**REQUEST**

Current Zoning: UMUD-O (uptown mixed-use district, optional)  
 Proposed Zoning: UMUD-O SPA (uptown mixed-use district, optional, site plan amendment)

The petition proposes to allow up to three electronic changeable copy signs totaling a maximum of ~~5,900~~ **4,800** square feet. The site is developed with a mixed-use office tower.

Stonewall Tower Development, LLC

SIGN LOCATION #3 - BROOKLYN VILLAGE AVE & CHURCH ST CORNER = 2,000 SF

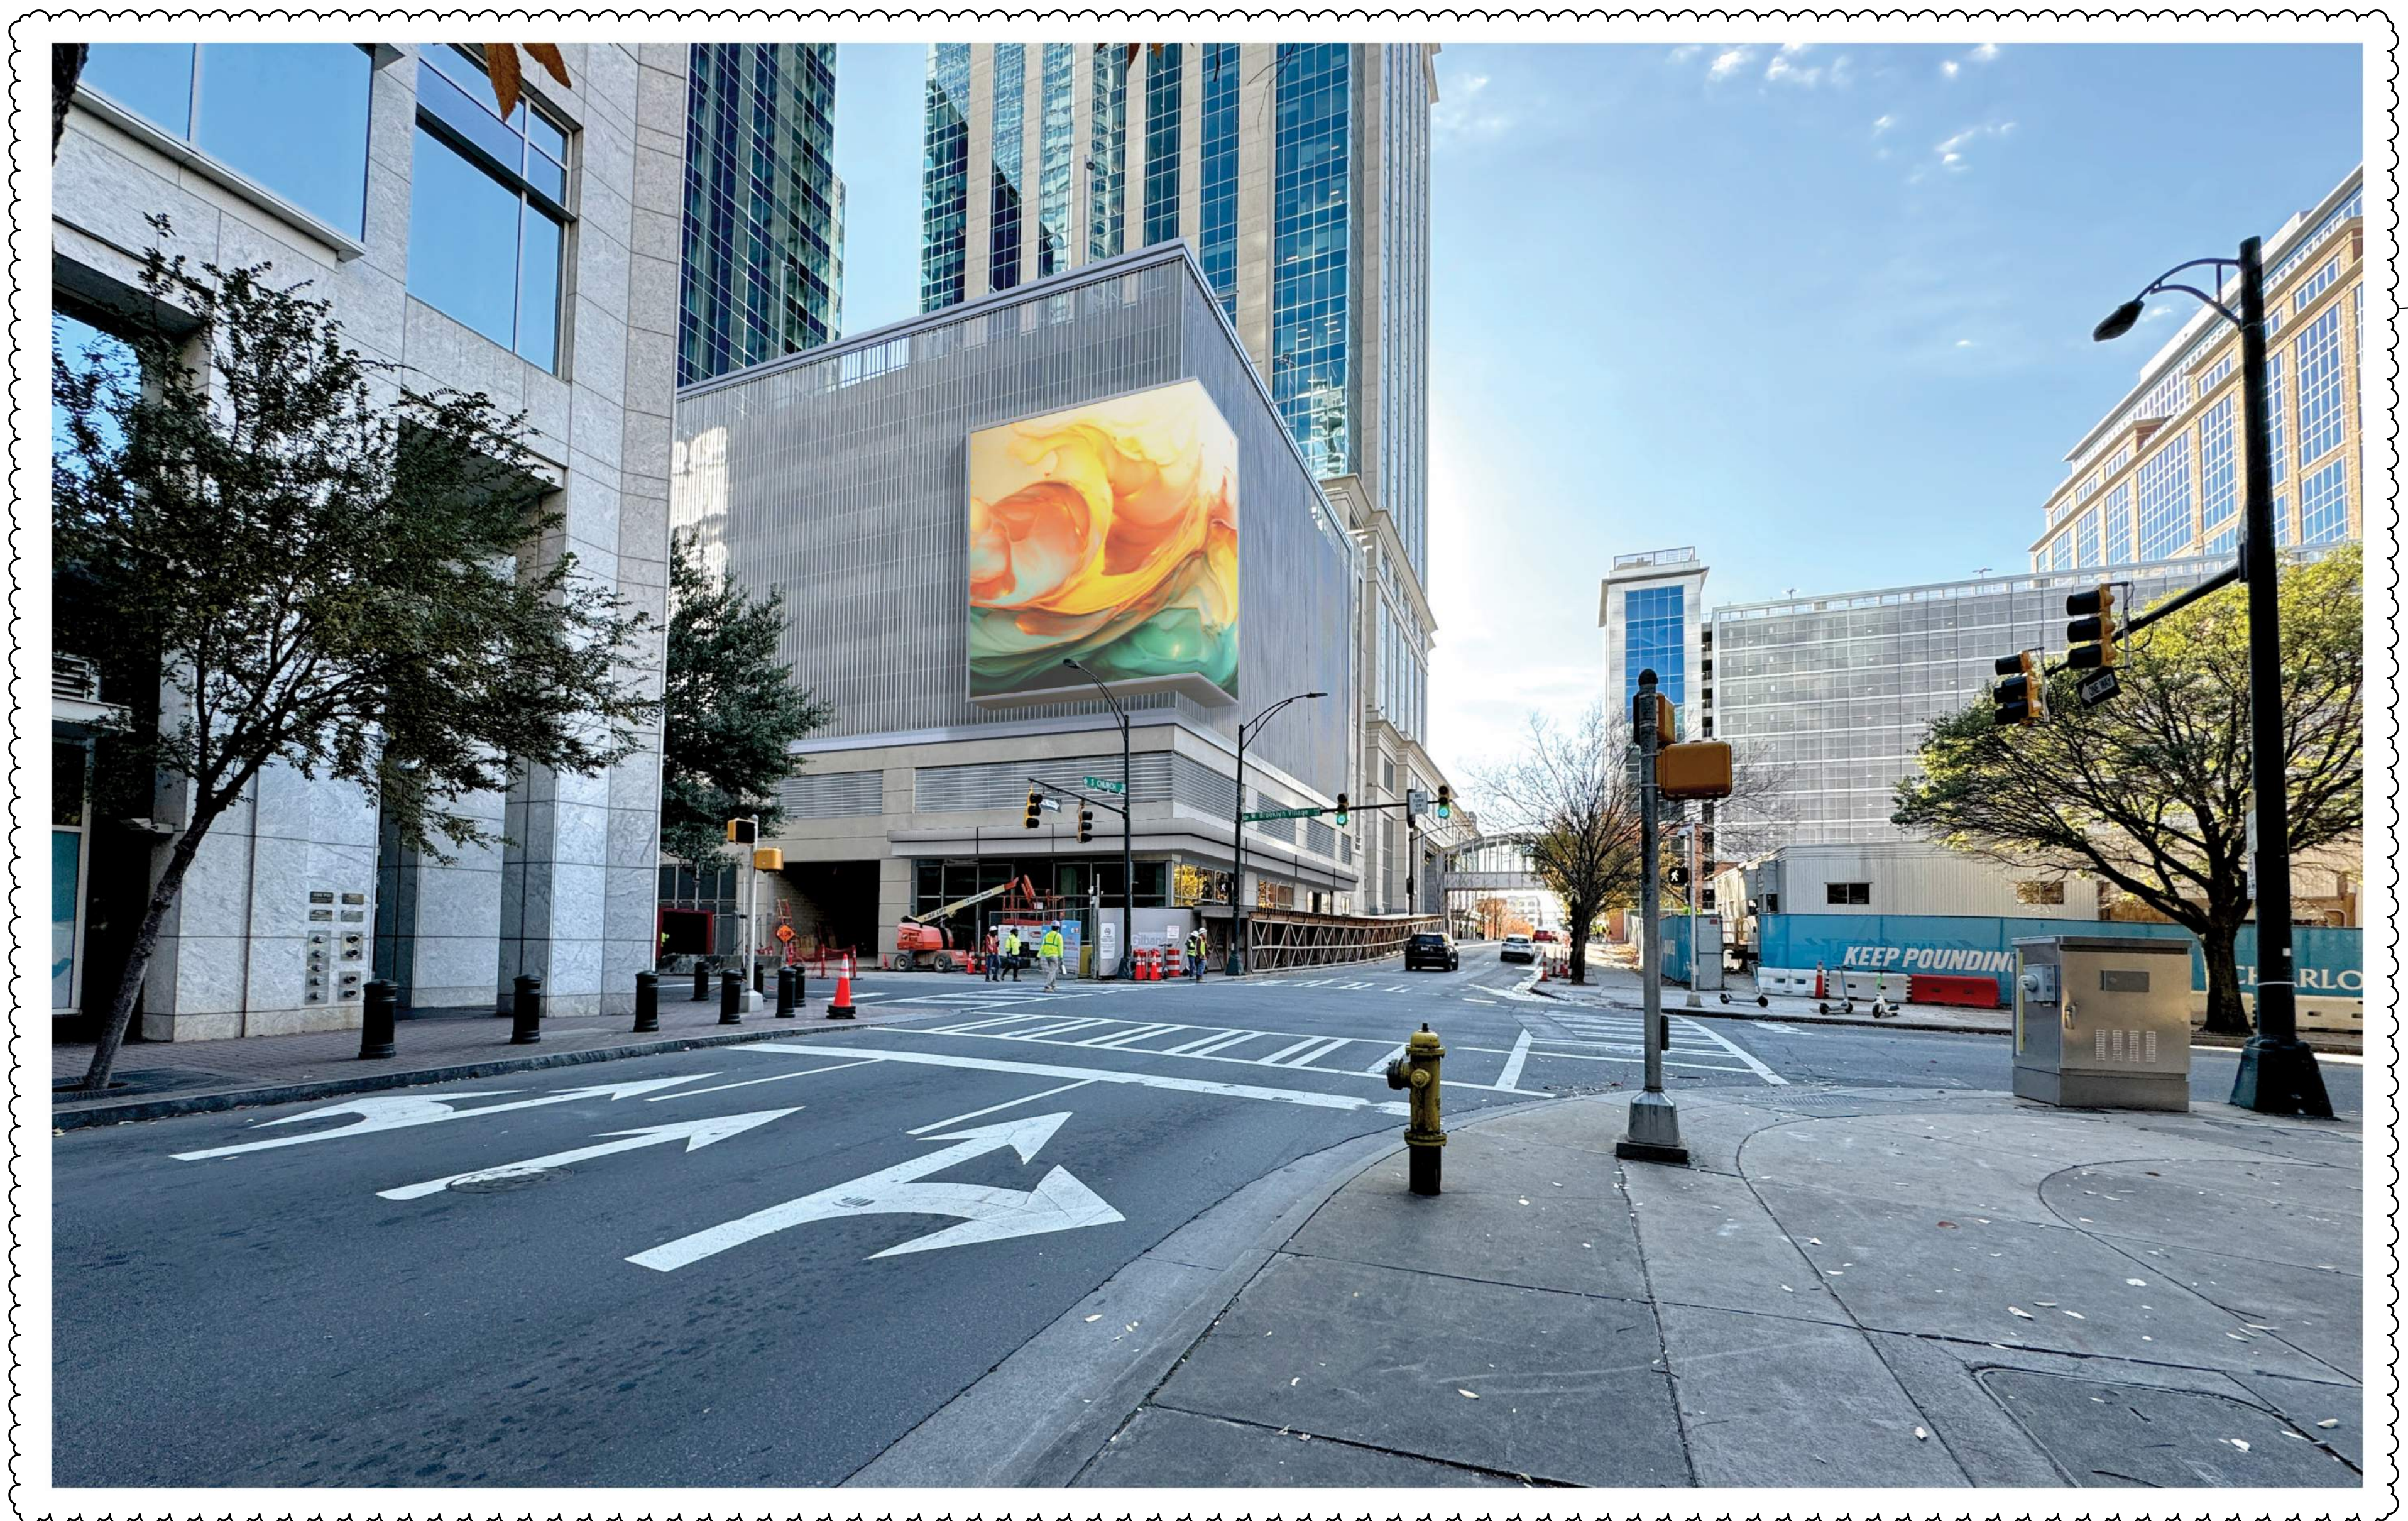
- Proposes to allow up to three electronic changeable copy signs totaling up to ~~5,900~~ 4,800 square feet.
  - Sign 1 at the site’s Tryon Street Plaza is proposed to be 1,400 square feet.
  - Sign 2 at Tryon Street and Brooklyn Village Avenue is proposed to be 1,400 square feet.
  - Sign 3 at Brooklyn Village Avenue and Church Street is proposed to be ~~3,100~~ 2,000 square feet.
